Application for a non-material amendment following a grant of planning permission. Town and Country Planning Act 1990

SINGLE STOREY SIDE/REAR EXTENSION

75542/APR/2020/1288

TO INSTALL A FRONT WINDOW INSTEAD OF
A GARAGE DOOR

PROPOSED FRONT ELEVATION

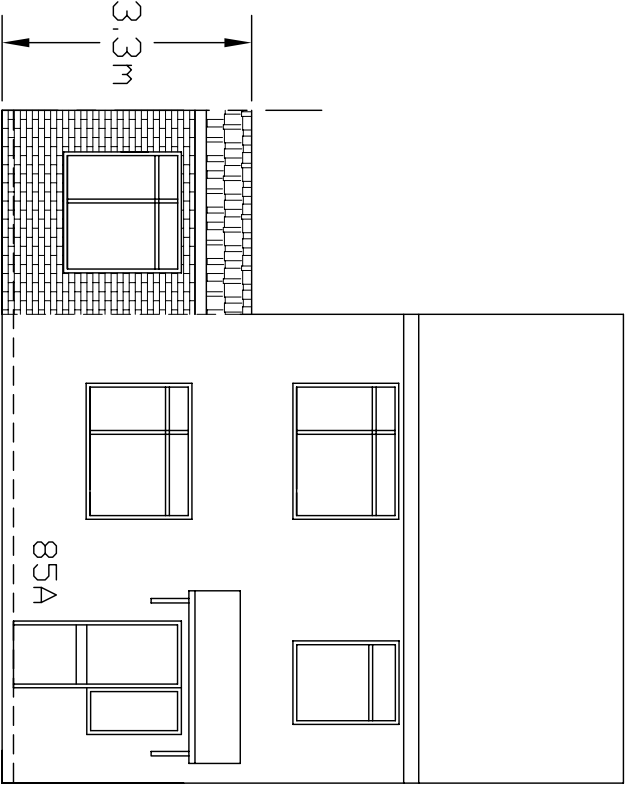
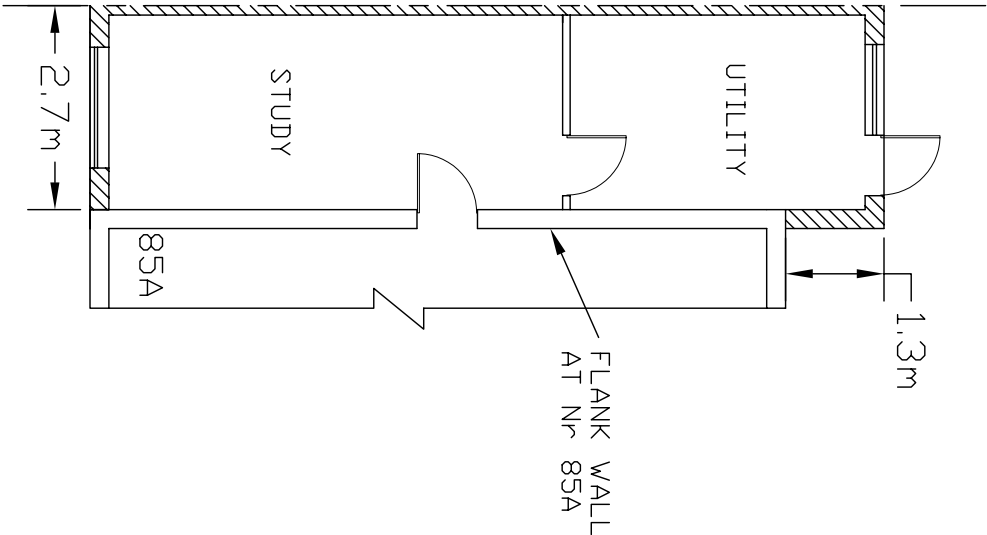
85A/LC/11 - FLOOR PLAN AND ELEVATIONS
